Your Reference SSD-77260958
Michelle Niles
Department of Planning, Industry and Environment
Via Major Projects Planning Portal

23 May 2025

**Submission to SSDA
20-24 Railway Parade and No.2-4 Burleigh Street, Burwood
Mixed Use Development**

DRAWING TITLE:
FACADE CONCEPT SECTIONS

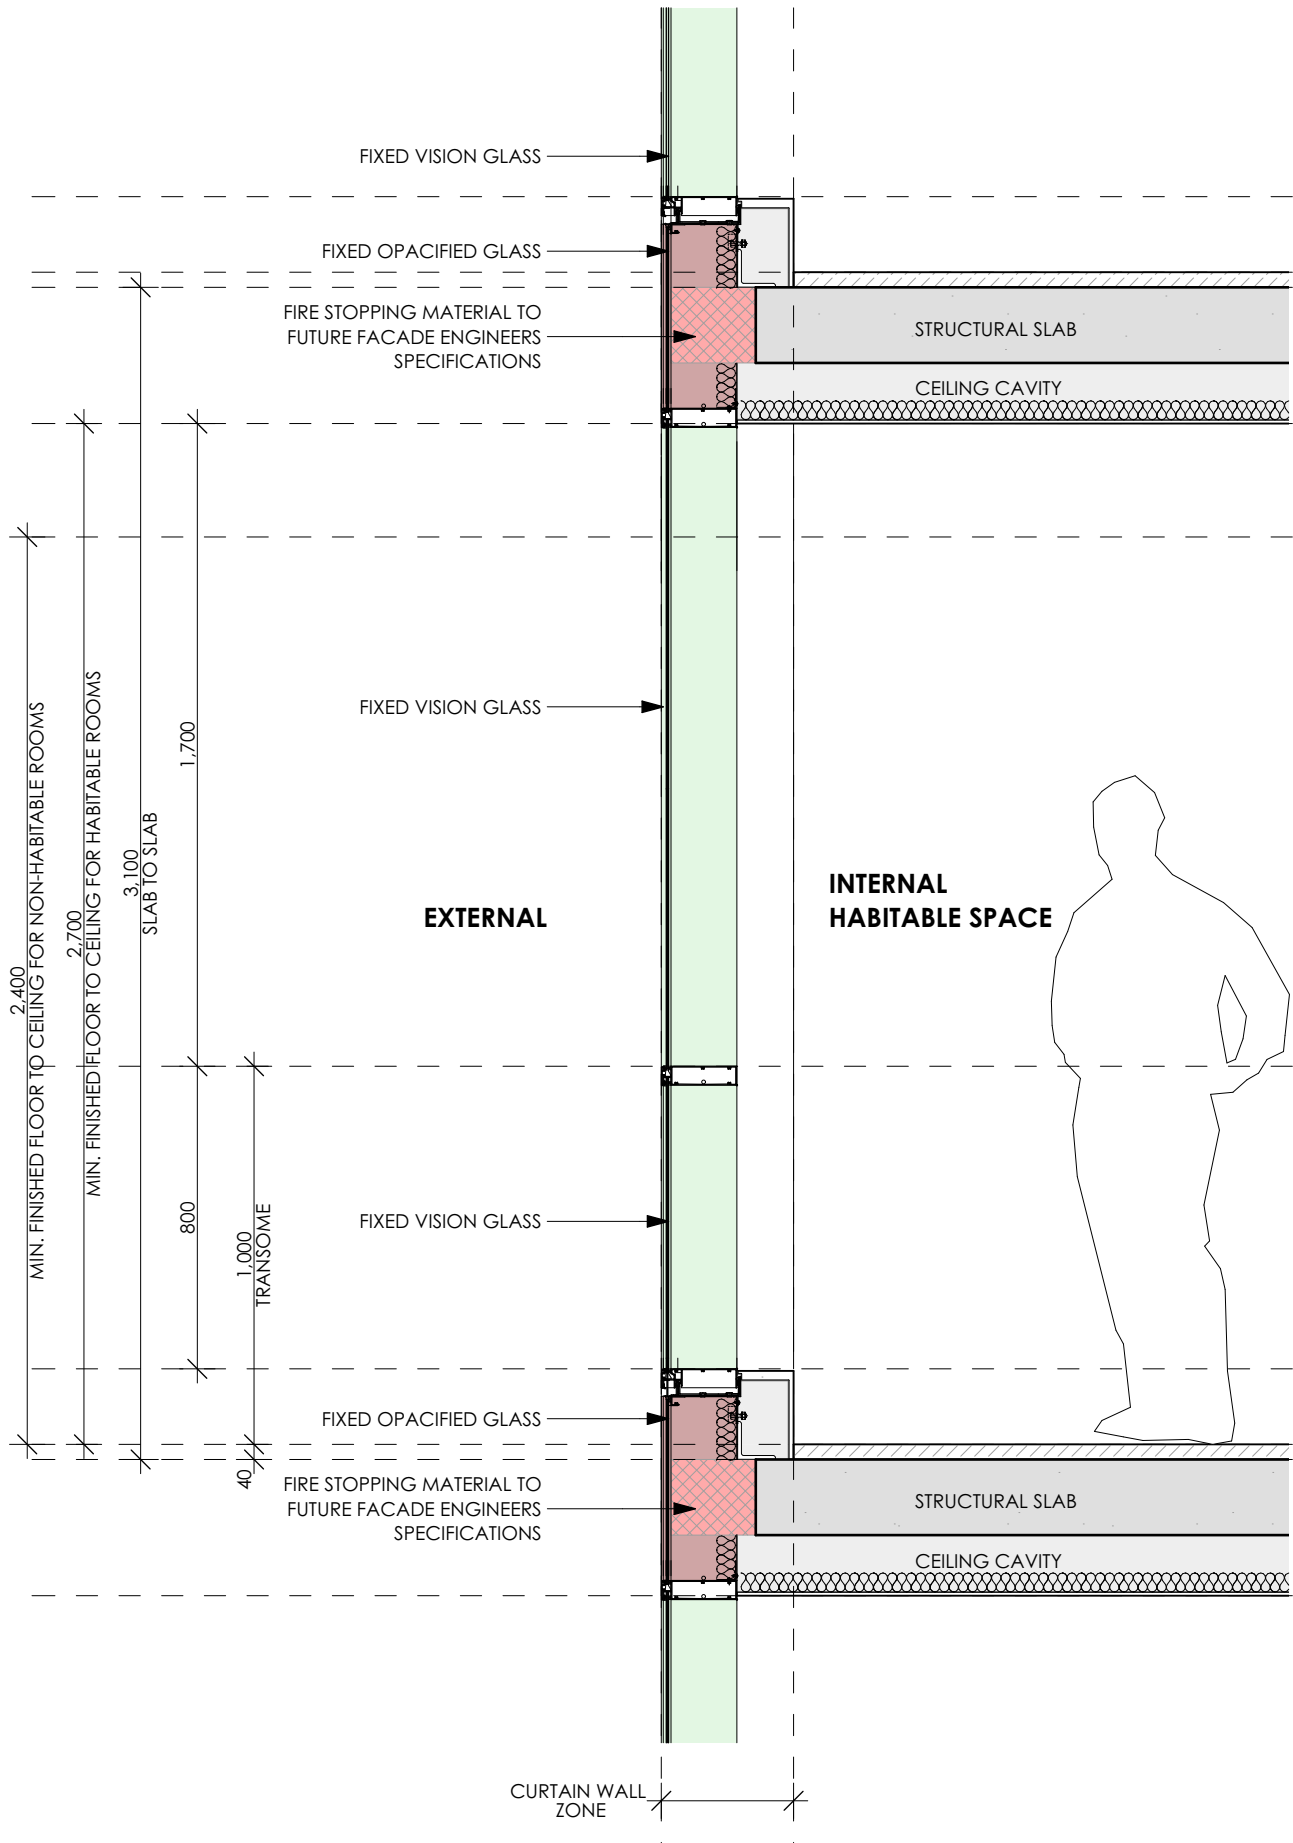
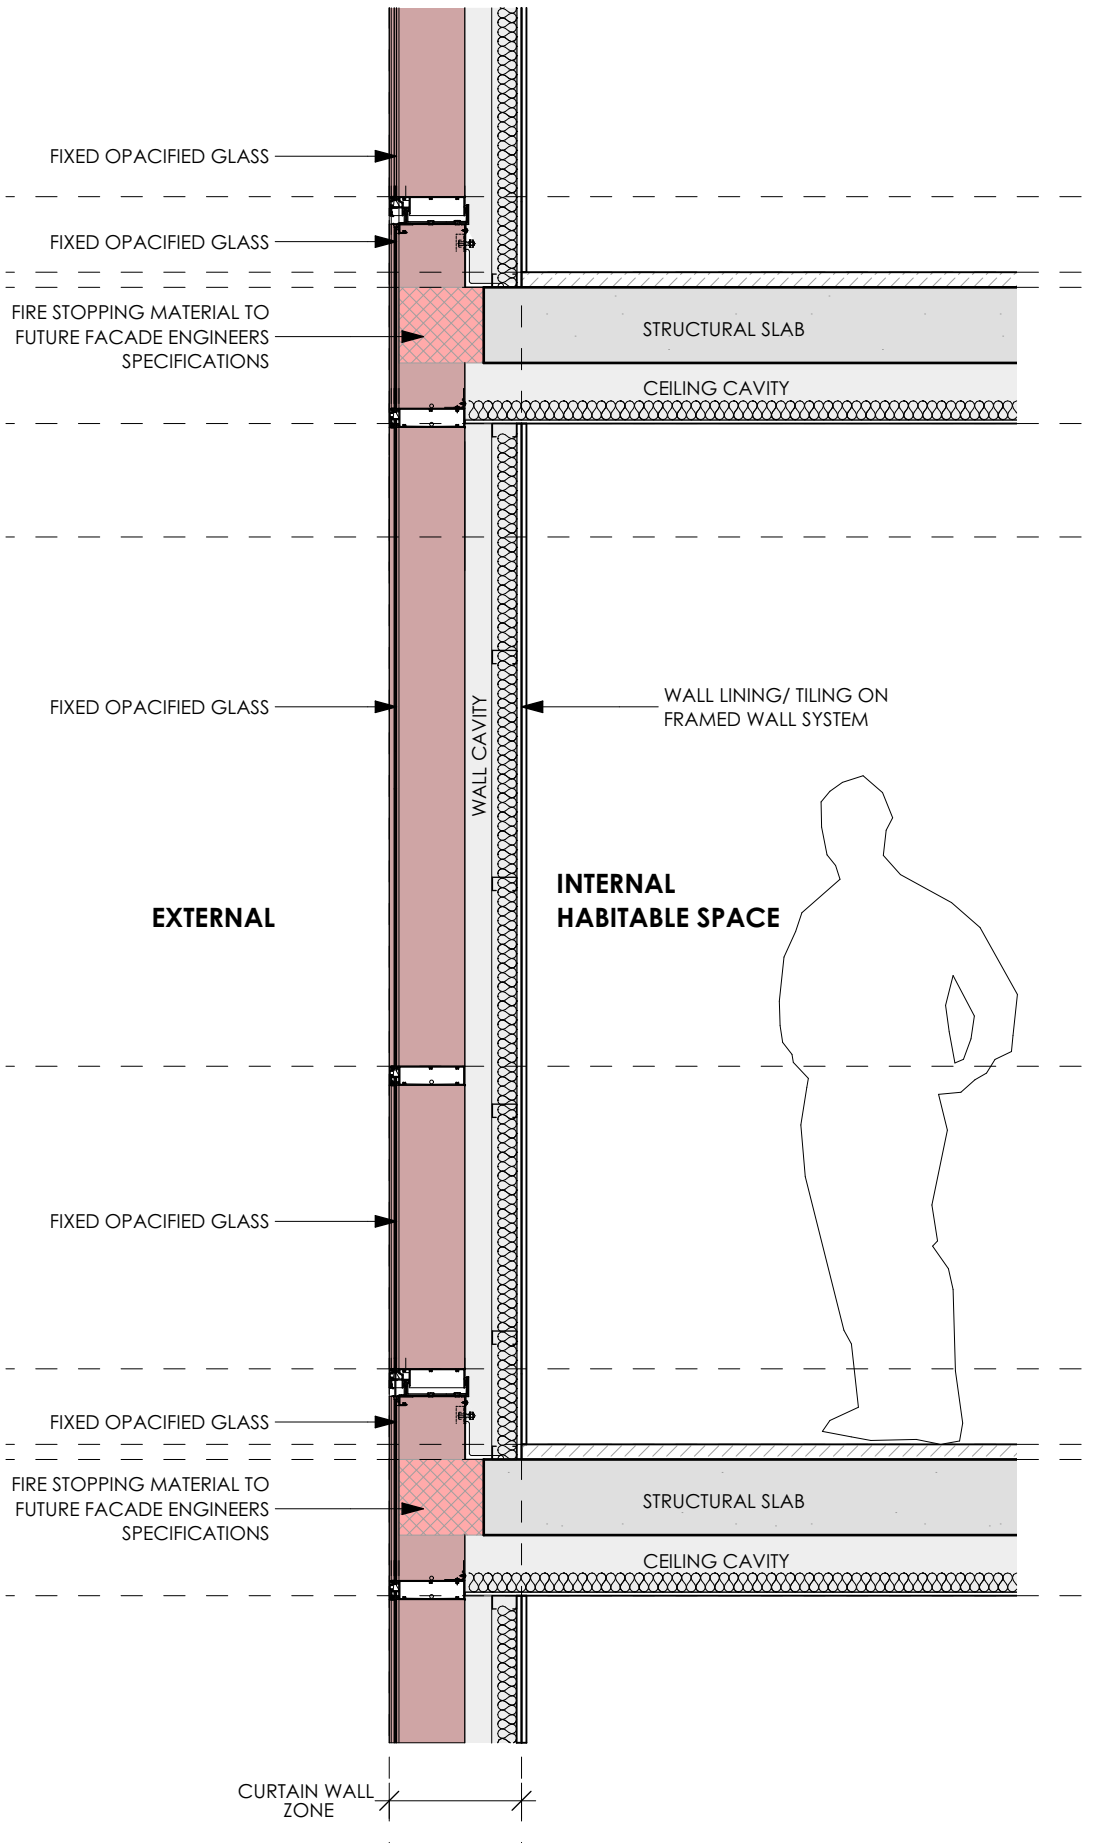
Notwithstanding Council's concerns with glazed façade, inadequate design details for curtain walls are shown.

Separation of external window openings to prevent spread of fire between levels must cover 900mm, with 600mm at minimum from the edge of floor above. Red arrows are critical information gaps where it is unknown how this curtain wall design will achieve compliance, or a performance solution warranted for the proposal.

The transome is 1000mm, and fixed vision glass is 800mm. Subtracting the fixed vision glass from transom leaves 200mm. **200mm of opacified glass, fixings and 40mm of flooring meant that the curtain wall construction has vertical protection (assumed) to 240mm.**

This meant 360mm of the minimum 600mm vertical protection is non-compliant.

There is no detail whether the material behind fixed opaque glass is non-combustible, including the structural slab and extent of fire resistance for those materials shown.
